**RE: OBJECTION TO RESIDENTIAL DEVELOPMENT WITH IN-FILL
AFFORDABLE HOUSING – REID STREET AND WOODSIDE AVENUE,
LINDFIELD, SSD-79261463**

PPTIES: 2-4 WOODSIDE AVENUE & 1-3 REID STREET, LINDFIELD

This submission relates to the proposed SSD at 2-4 Woodside Avenue & 1-3 Reid Street, Lindfield.

PLANNING ENVELOPE - HOB

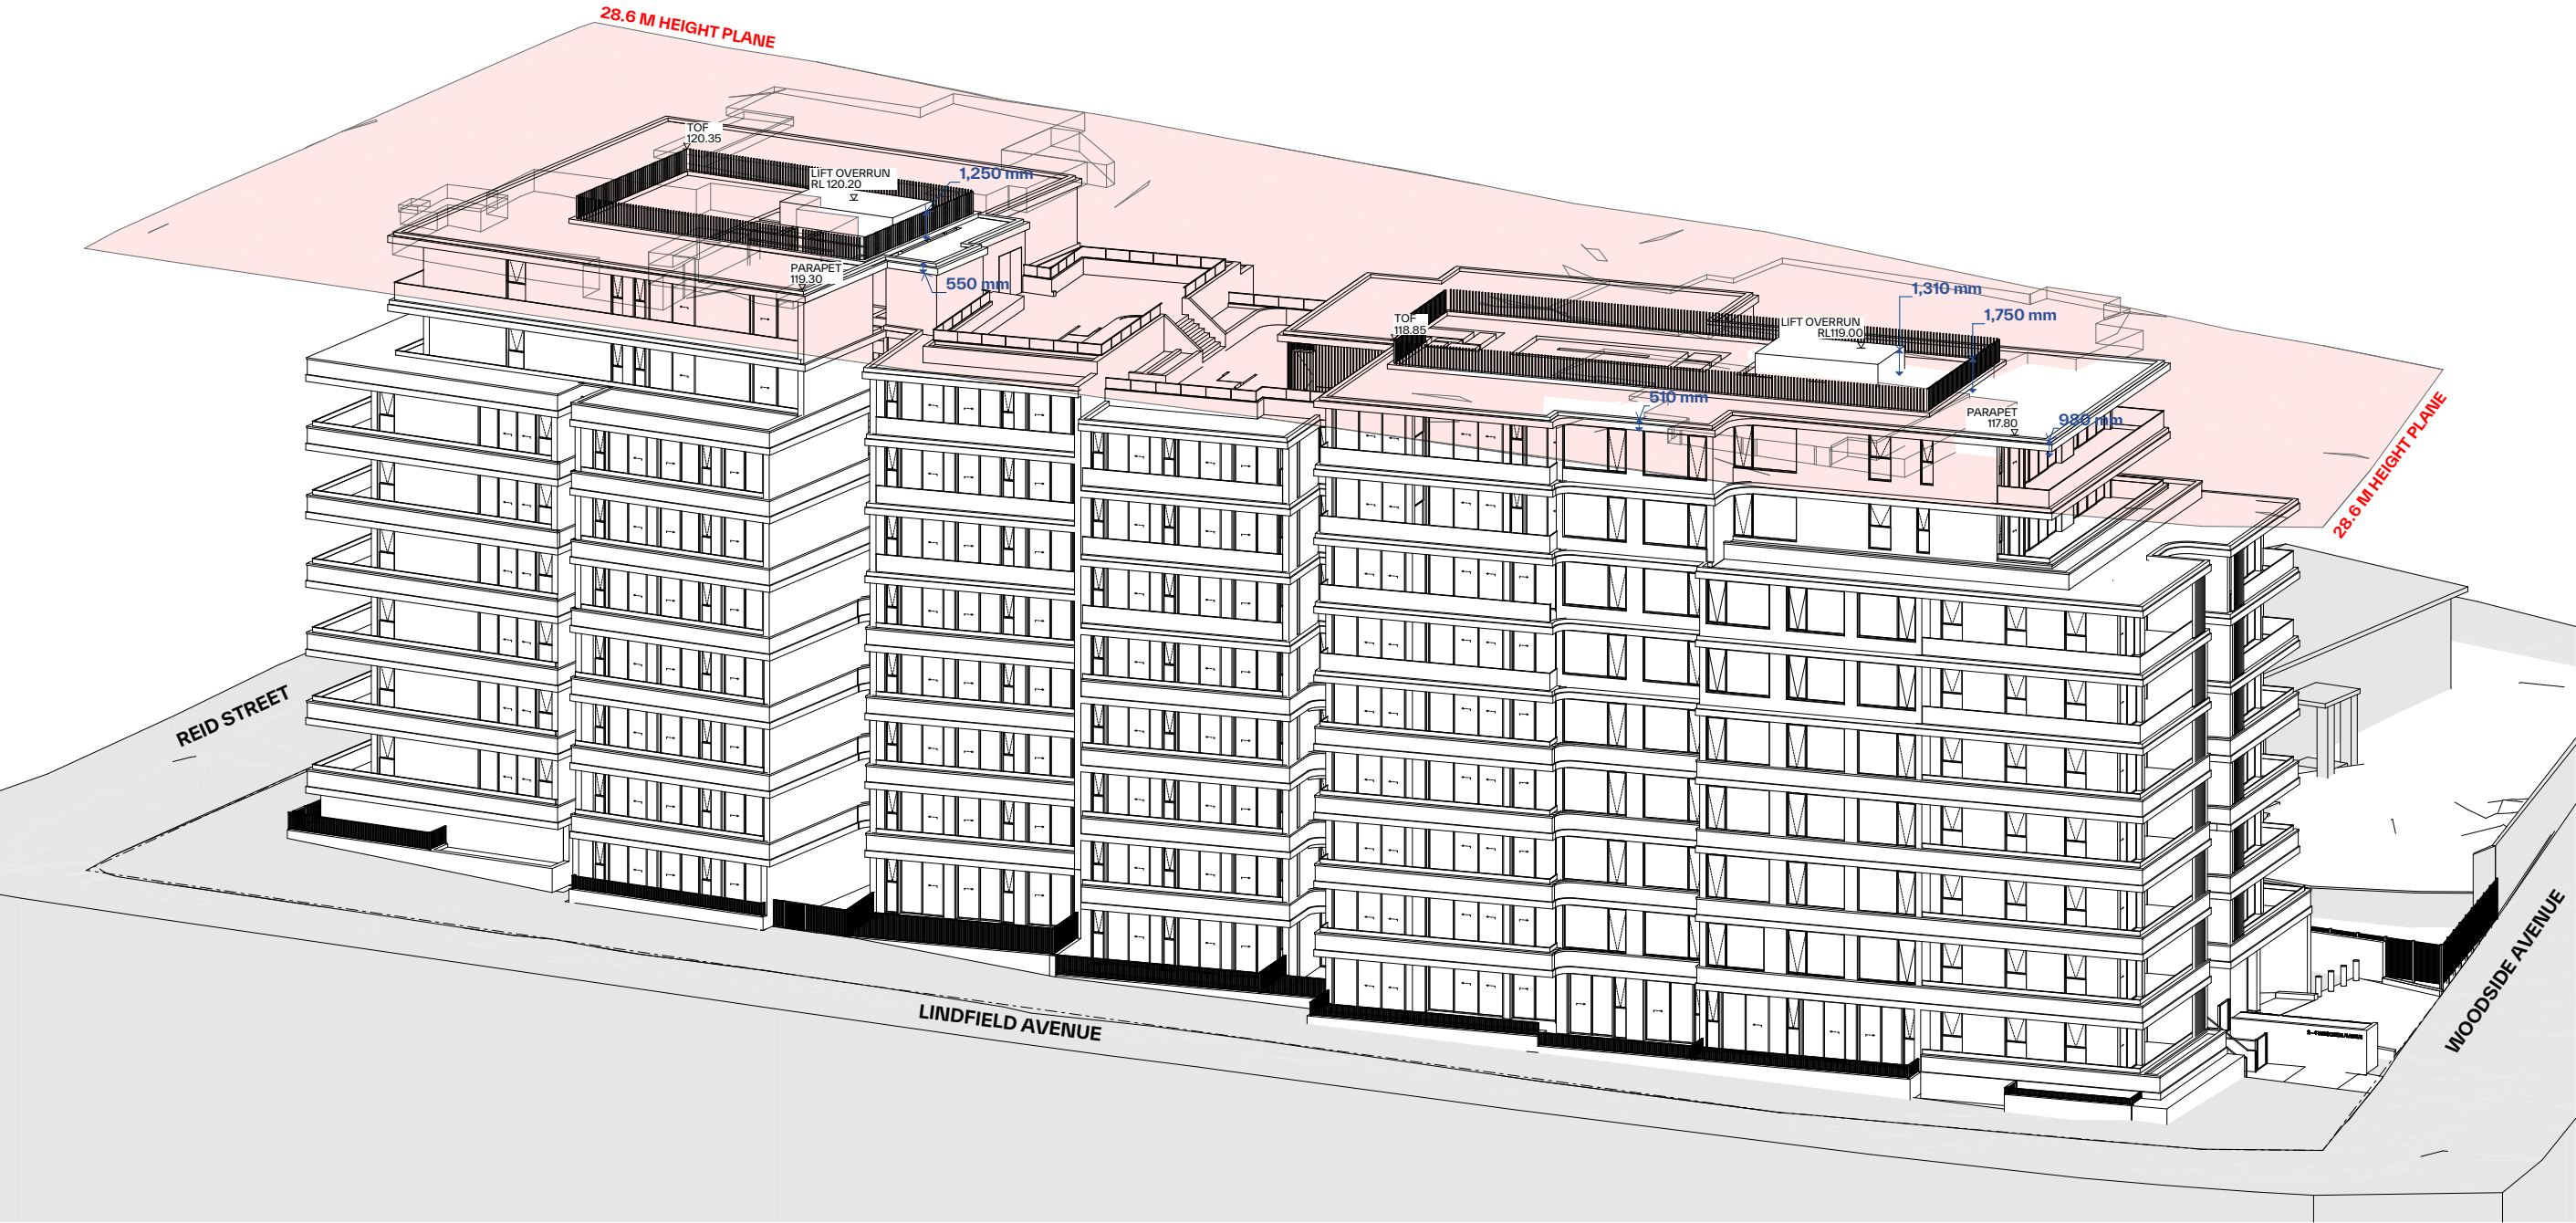
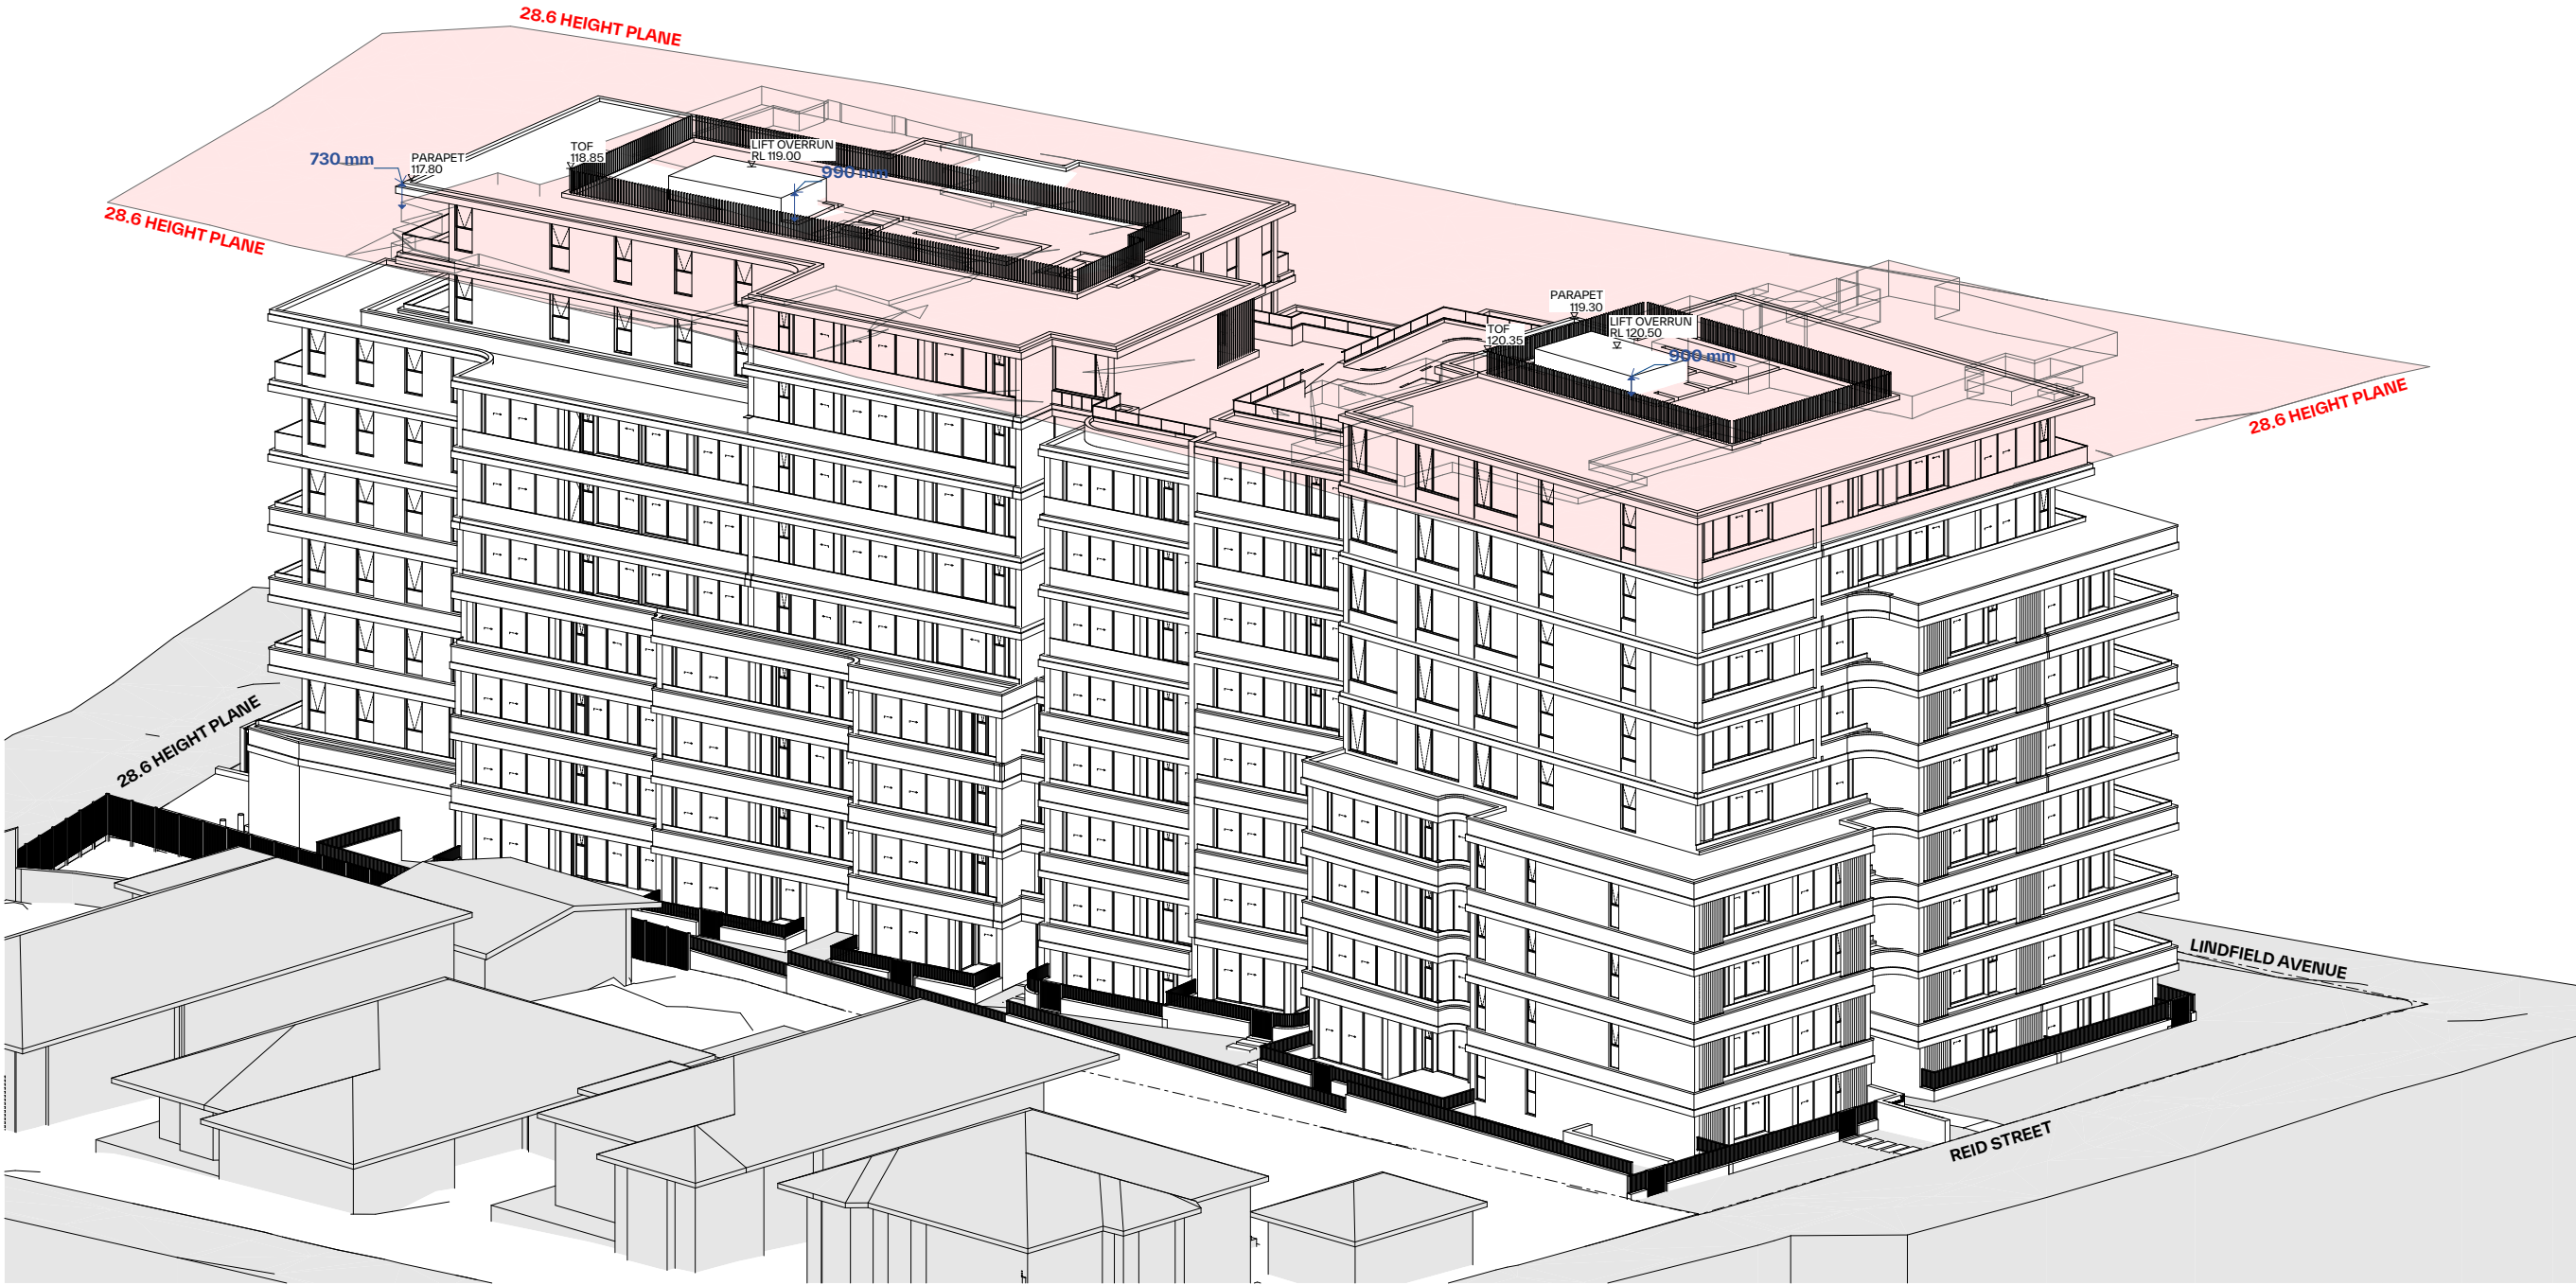
- Breach of the Height of Buildings Standard.
- Breaches of the Solar Access Control in relation to the following: -
 - i. The Applicant had highlighted in yellow colour those proposed units which are claimed to receive the requisite level of sunlight, but many of the windows are associated with bedrooms which are not "*living rooms*". In fact, the claimed "*compliance*" is only achieved when including
